CITY OF PORTLAND, MAINE
DEVELOPMENT REVIEW APPLICATION
PLANNING DEPARTMENT PROCESSING FORM

Garsoe Drive Lot #5

CITY OF PORTLAND, MAINE
 SITE PLAN REVIEW (ADDENDUM)
 CONDITIONS OF APPROVAL

APPLICANT: DON & Ellen Miller
 ADDRESS: 144 Dendron Rd. Peacedale, RI 02883
 SITE ADDRESS/LOCATION: 45 GARSOE DRIVE
 DATE: 4-20-2000

SITE PLAN, LOT 5

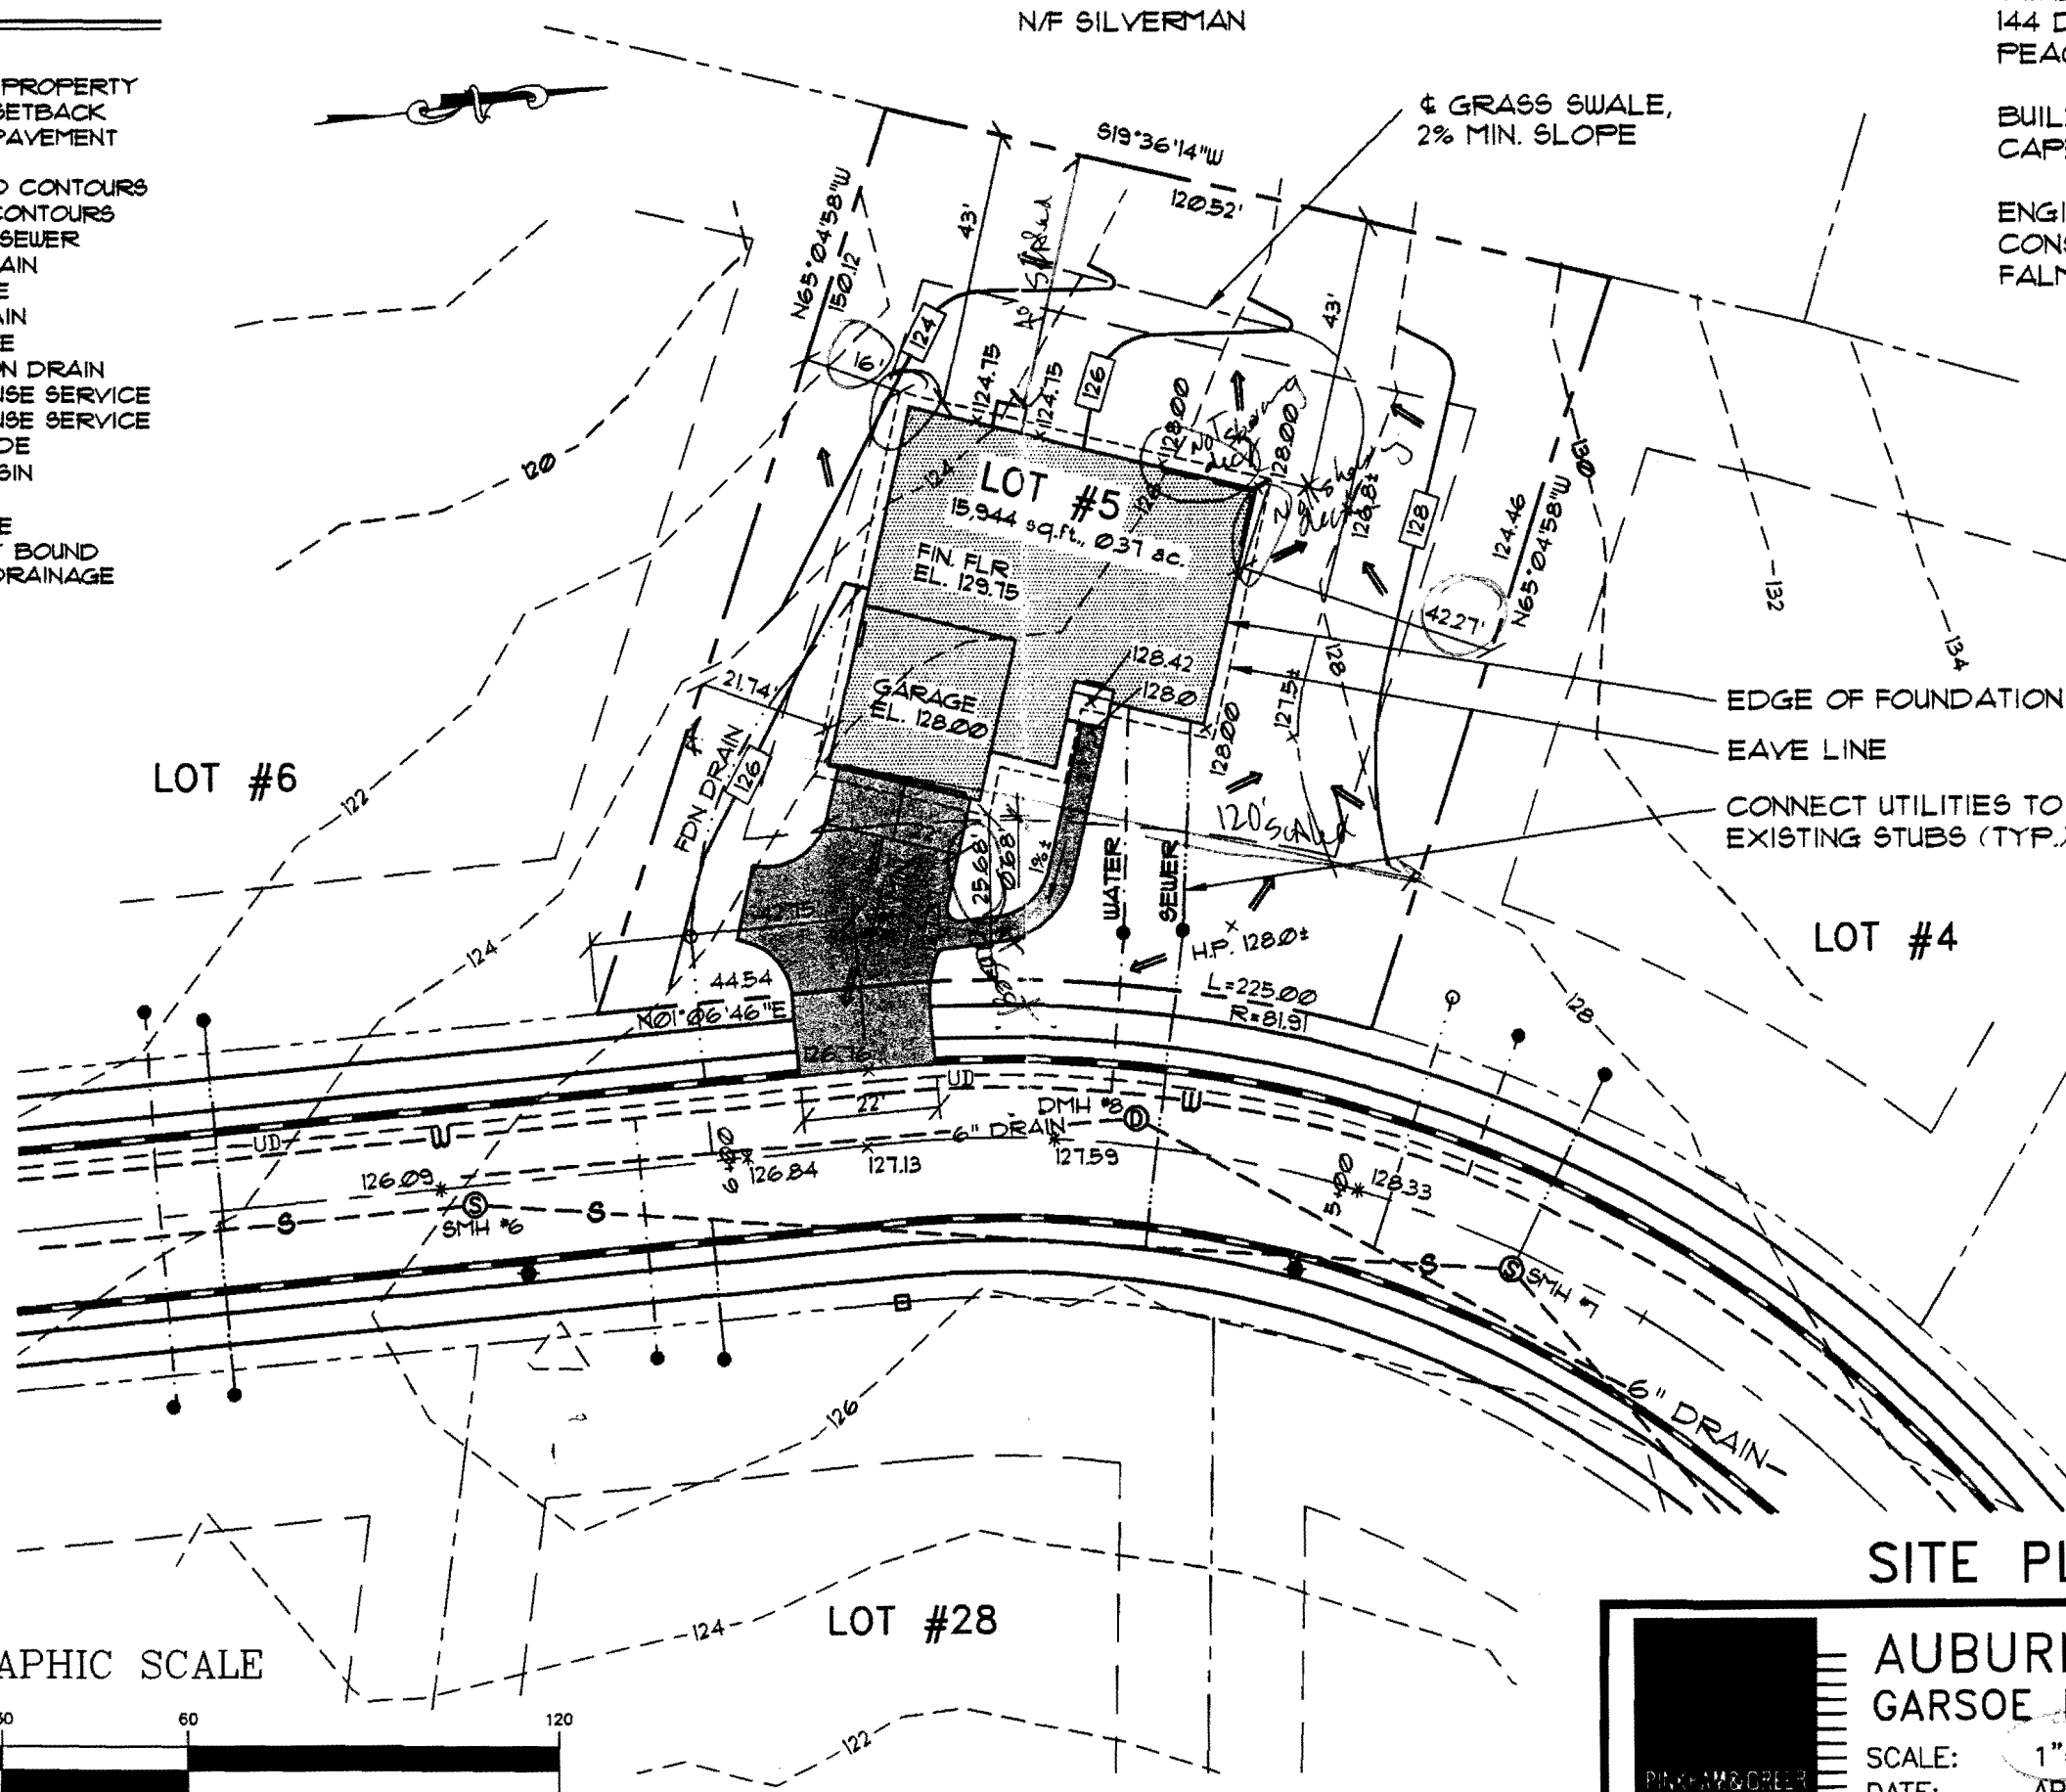
9. X The building contractor shall check the subdivision recording plat for pre-determined first floor elevation and establish the first floor elevation (FFE) and sill elevation (SE) to be set above the finish street/curb elevation to allow for positive drainage away from entire footprint of building.

10. X The site contractor shall establish finish grades at the building foundation, bulkhead and basement windows to be in conformance with the first floor elevation (FFE) and sill elevation (SE) set by the building contractor to provide for positive drainage away from entire footprint of building.

11. X A drainage plan shall be submitted to and approved by Development Review Coordinator showing first floor elevation (FEE), sill elevation (SE), finish street/curb elevation, lot grading, existing and proposed contours, drainage patterns and paths, drainage swales, grades at or near abutting property lines, erosion control devices and locations and outlets for the drainage from the property.
